Applicant's Responses to Deadline 6 Submissions

The West Midlands Rail Freight Interchange Order 201X

THE WEST MIDLANDS RAIL FREIGHT INTERCHANGE ORDER 201X
APPLICANT'S RESPONSES TO DEADLINE 6 SUBMISSIONS - DOCUMENT 17.1

Transport Technical Note 45 – Response to Connect Technical Note 02.

APPENDIX D: 2015 BASELINE LINK FLOW DIAGRAMS

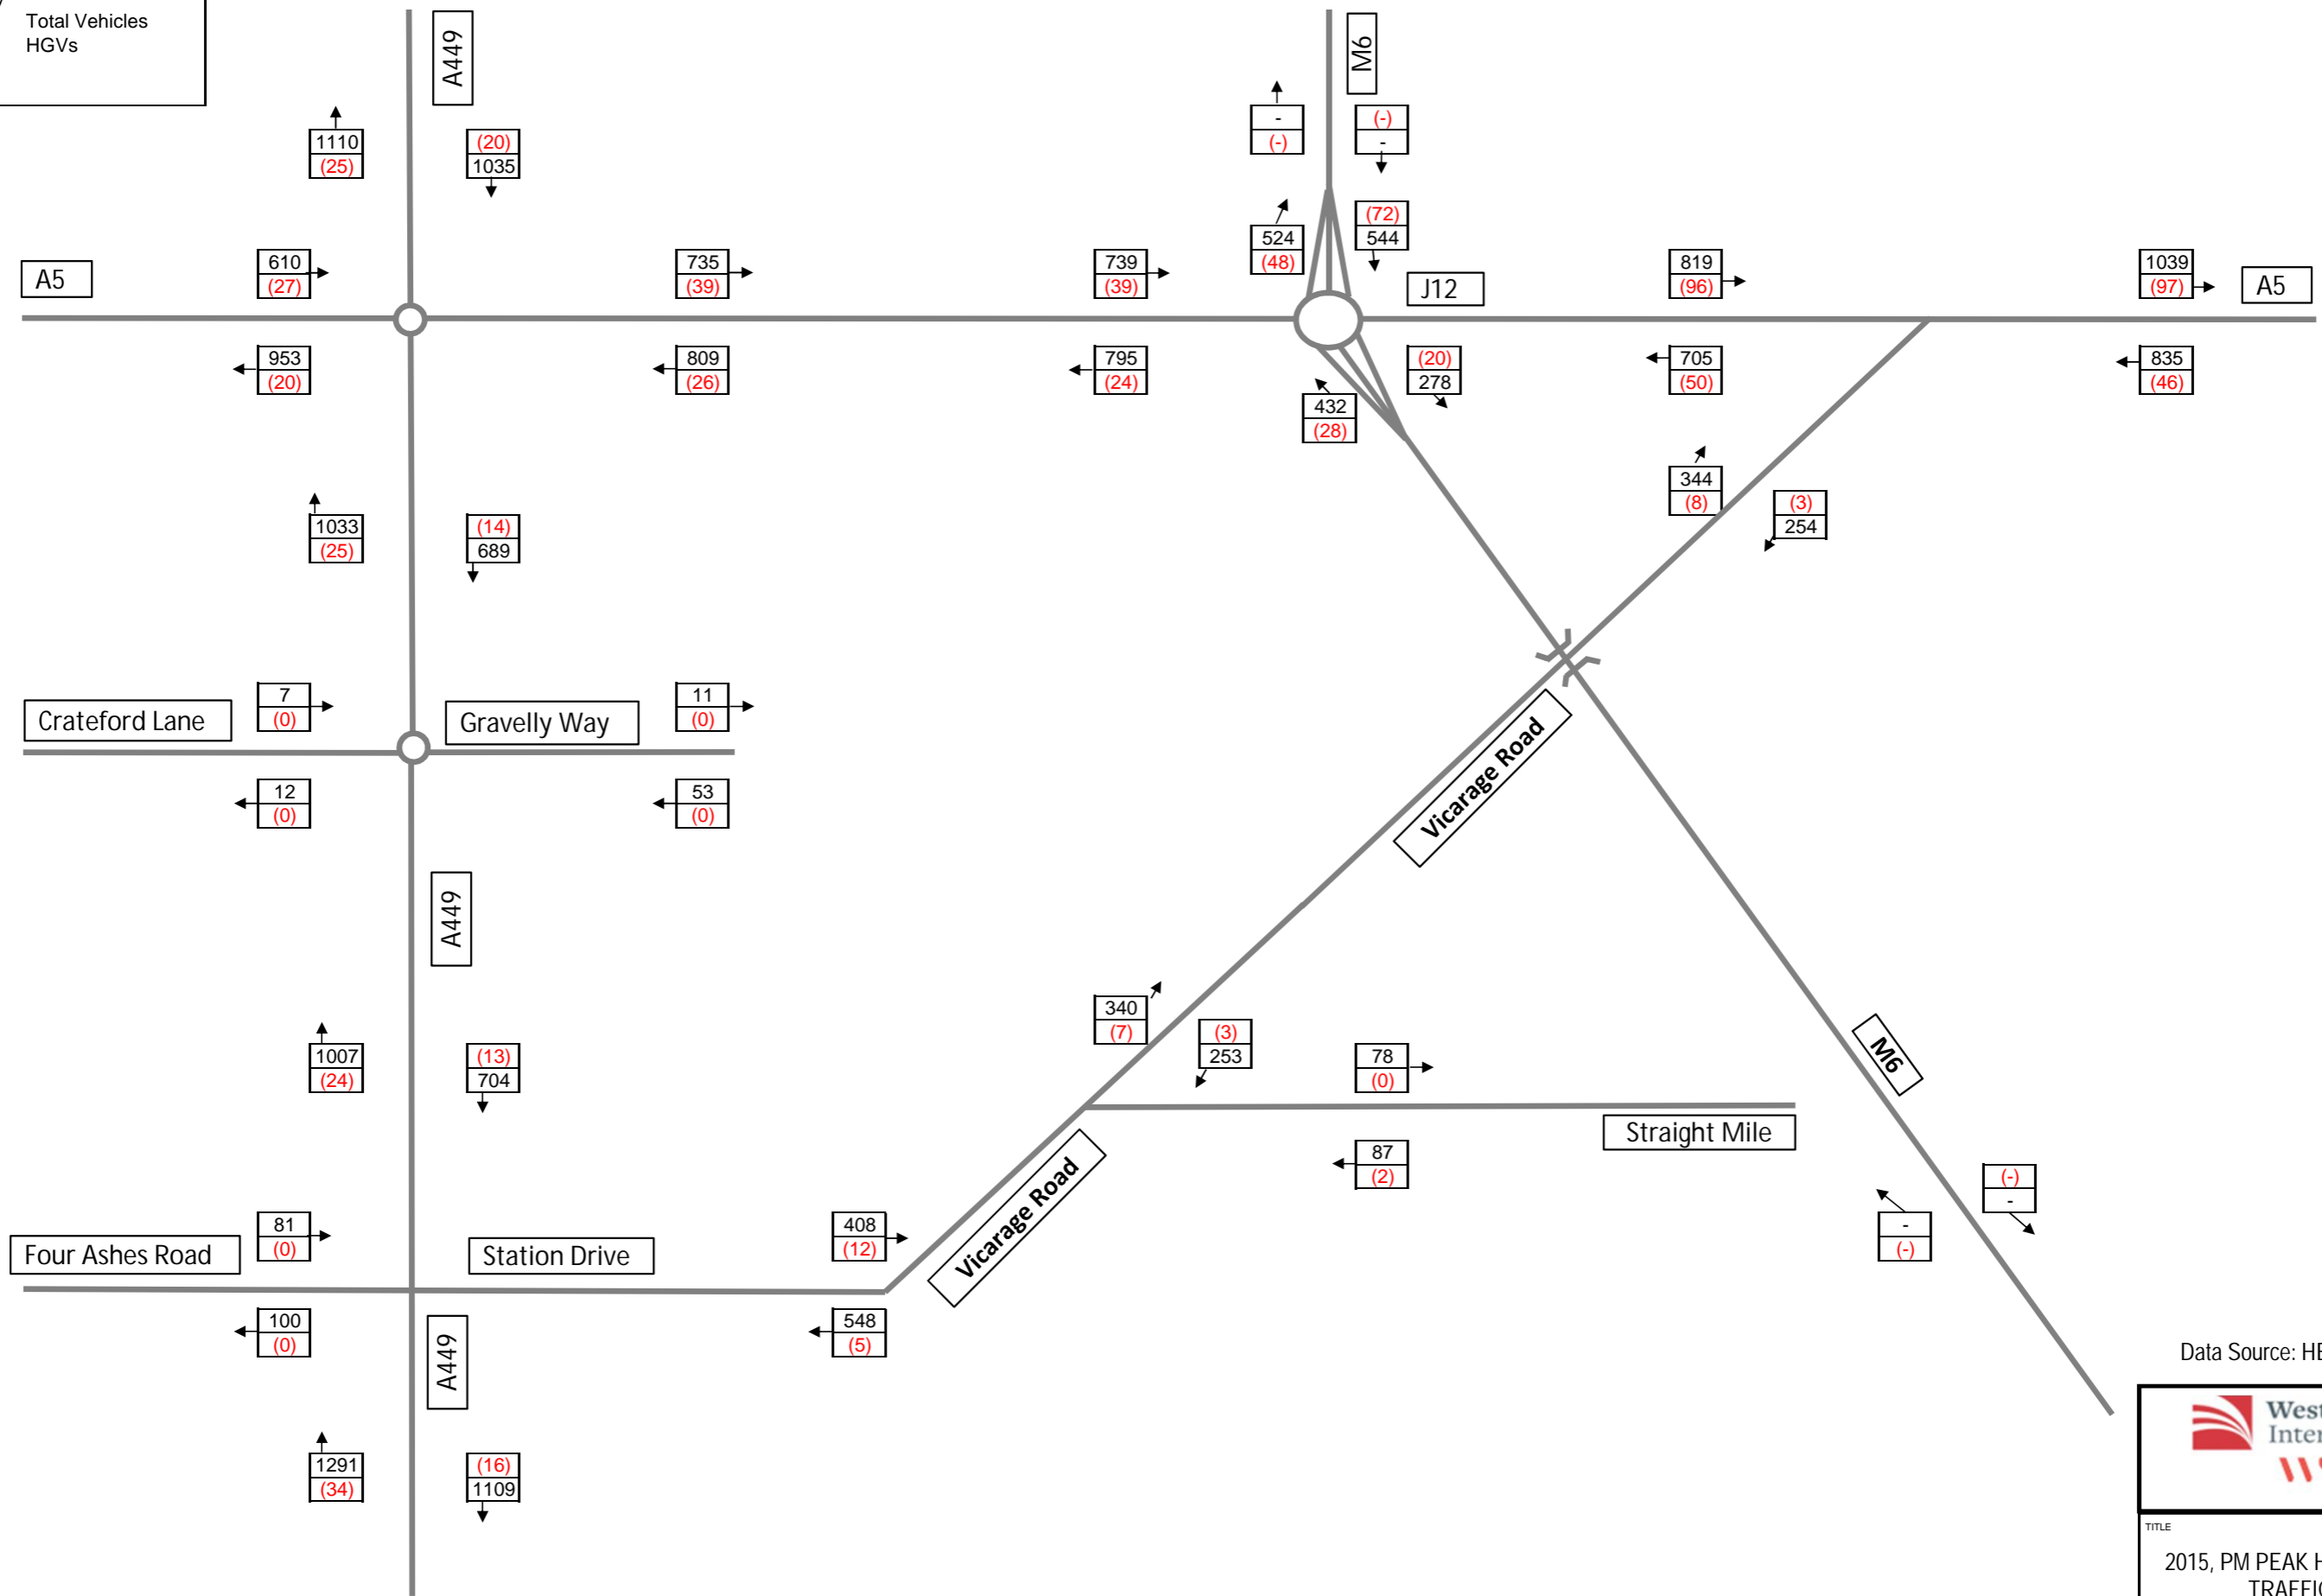
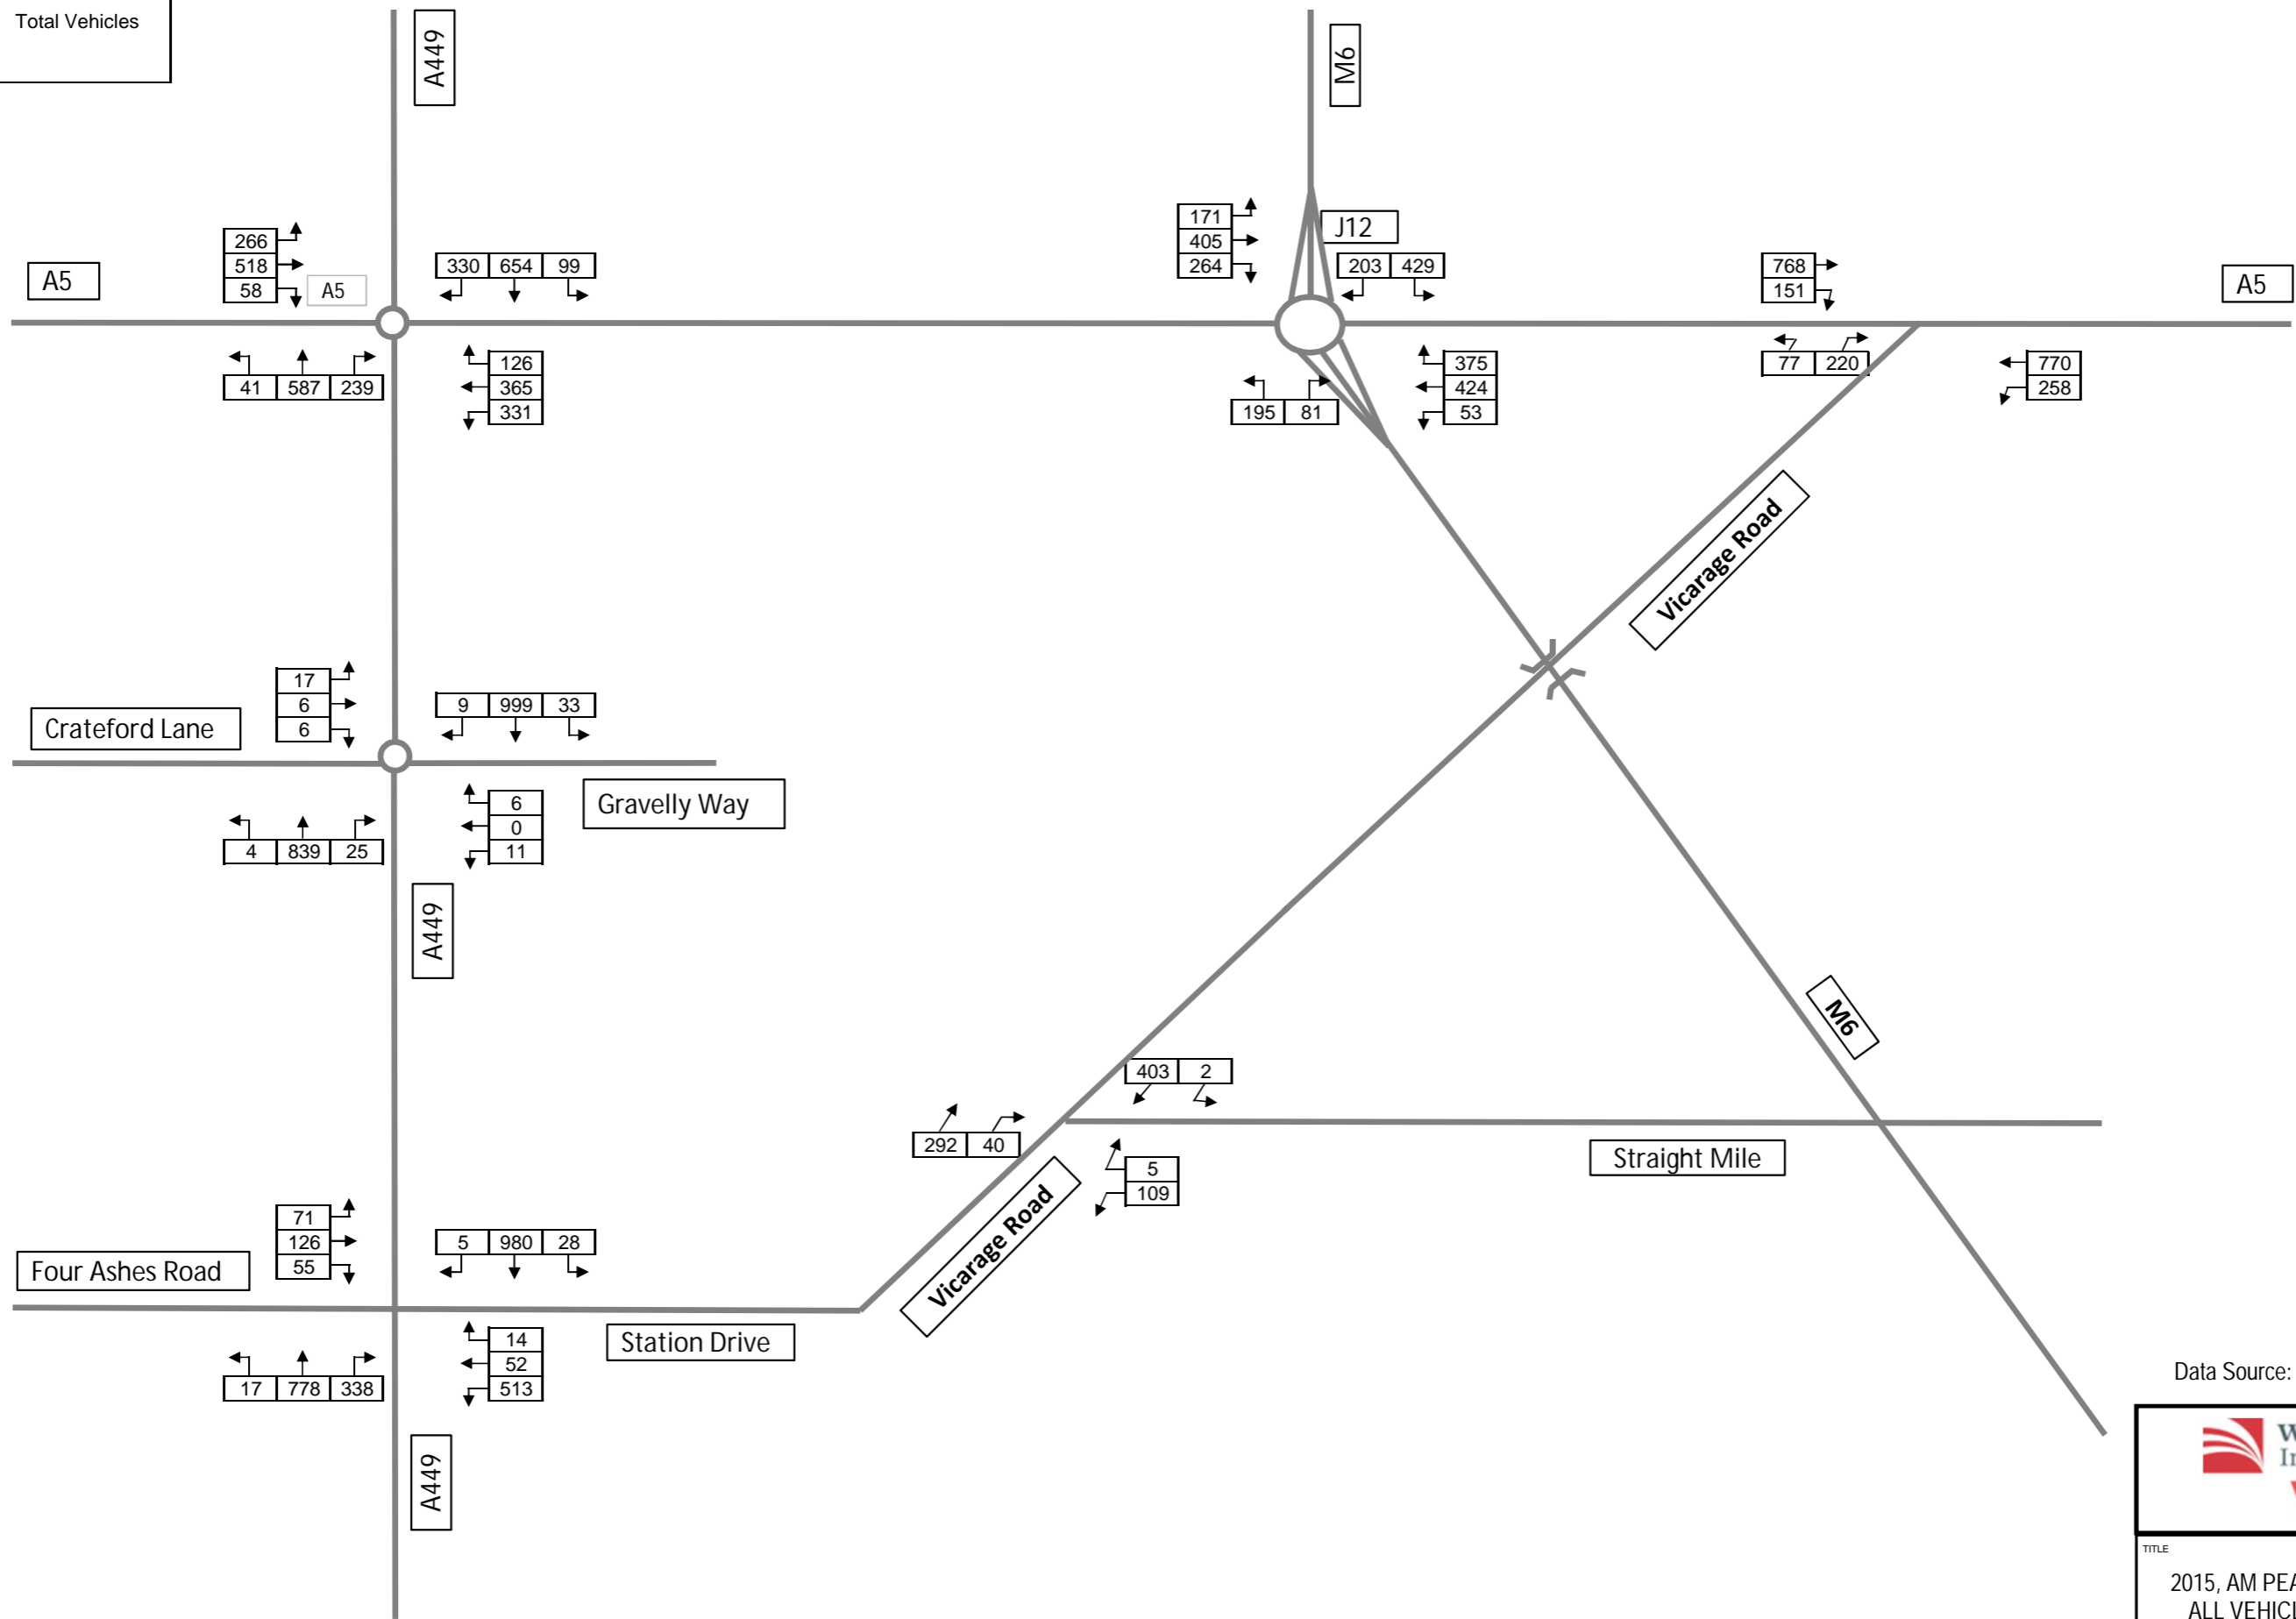
- 2.1 At paragraphs 2.5 – 2.8 of TN 02, Connect assert that there are errors in the traffic flow diagrams (APP-146) submitted with the application and call into question the reliability of the analysis. The specific issue they are referring to relates to the absence of U-turning traffic at the A449 site access roundabout in traffic flow diagrams (APP-146) included in the Transport Assessment (APP-114). WSP acknowledge that the specific U-turn movement from A449 south to A449 south is not shown on the traffic flow diagram at the A449 site access roundabout, however, the changes in traffic flows at the A449 / Station Drive junction to the south, as a result of the U-turning traffic, is included on the diagrams.

- 2.2 The junction turning movements provided to us by the VISSIM modellers (Systra) did not report the U-turn movements at any junctions, however, these u-turning traffic movements are modelled and included

2.3 Therefore, the Applicant can confirm that the traffic flows assessed and all analysis presented is correct and there are no errors. This position has been accepted by both Highways England and Staffordshire County Council.
